App No: A/177/19/PL

Address: The Vinery Arundel Road Poling BN18 9PY

Proposal: New building for storage or distribution, light industrial & office (Class B1/B8) & associated parking. This application is a Departure from the Development Plan & may affect a Public Right of Way.

Appendix F: Wildlife mitigation and enhancements

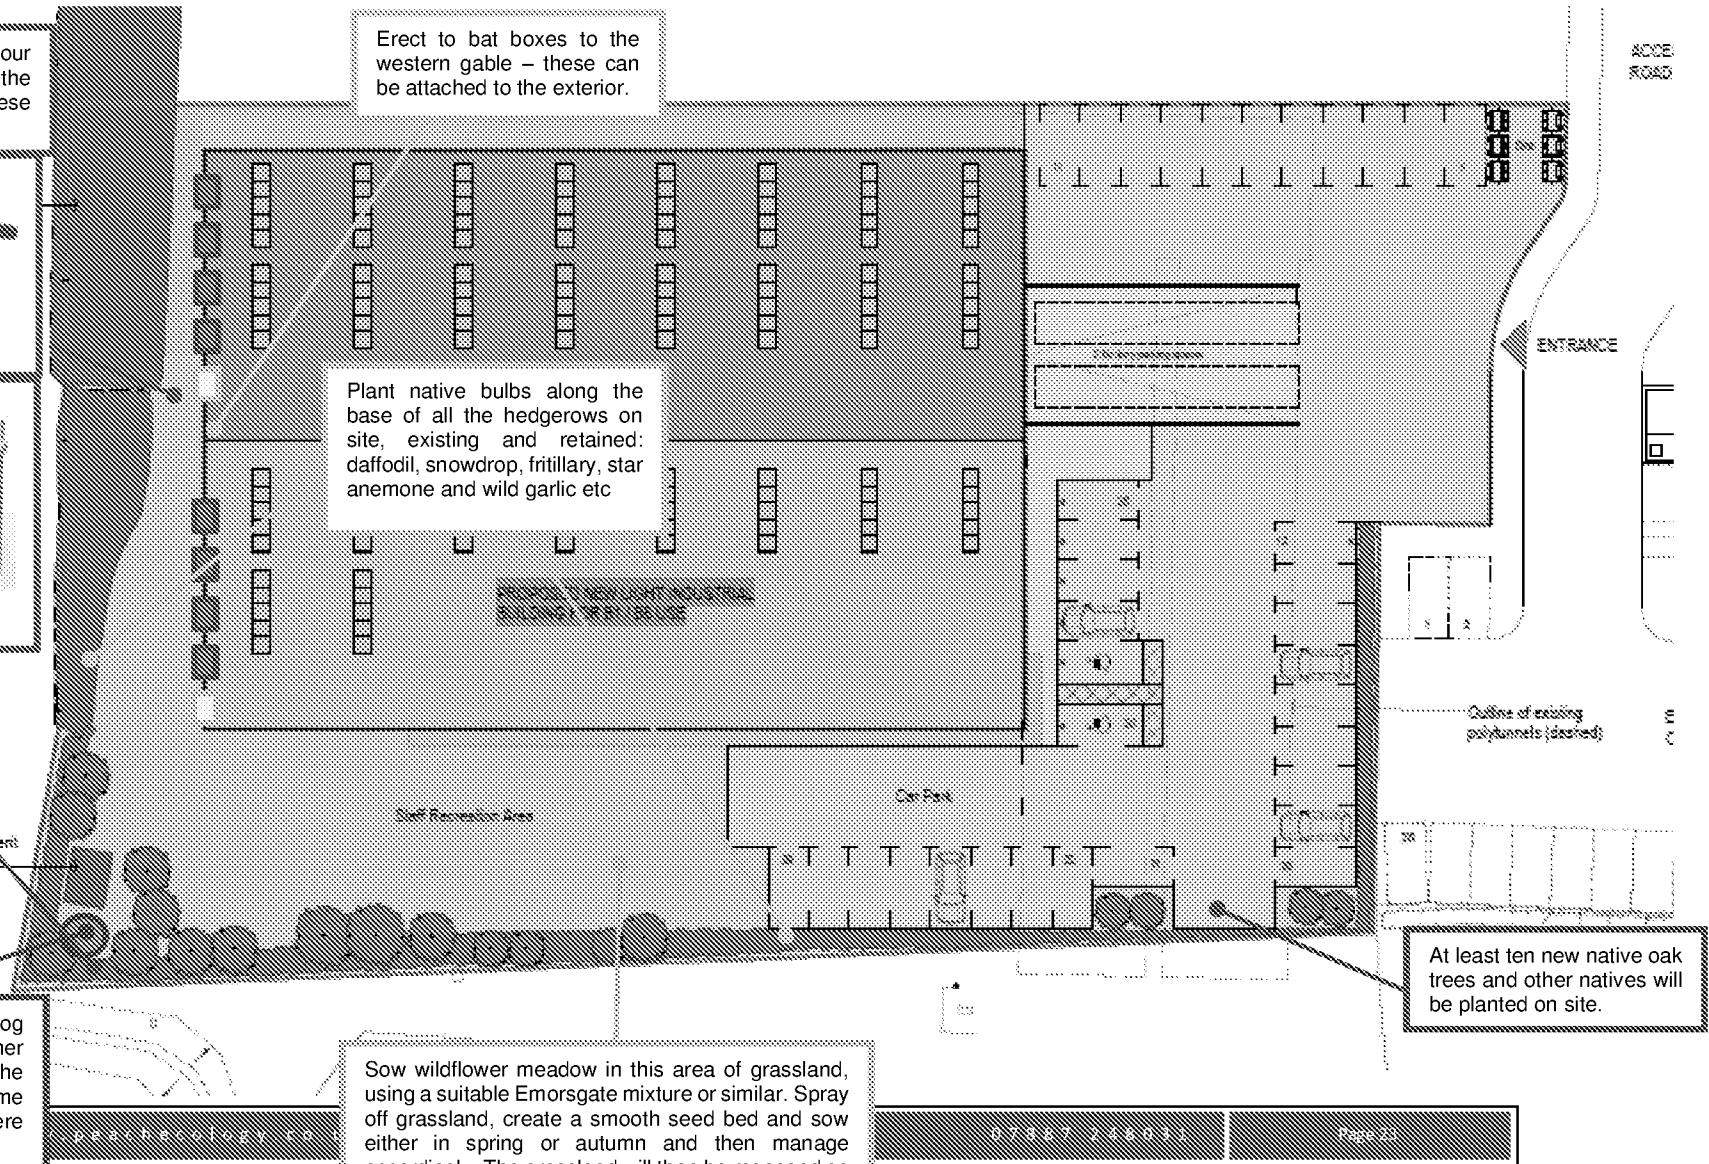
- The fallen oak tree on the site as detailed within the ecological appraisal should be left onsite to rot down over time and provide a valuable habitat of invertebrates onsite.
- Any trees removed should be replace at a ratio of 2:1
- Wildflower meadow planting used
- Filling any gaps in tree lines or hedgerows with native species
- Bat and bird boxes installed on the site
- Grassland areas managed to benefit reptiles.
- We require that gaps are included at the bottom of the fences to allow movement of small mammals across the site
- two hedgehog nesting boxes included on the site
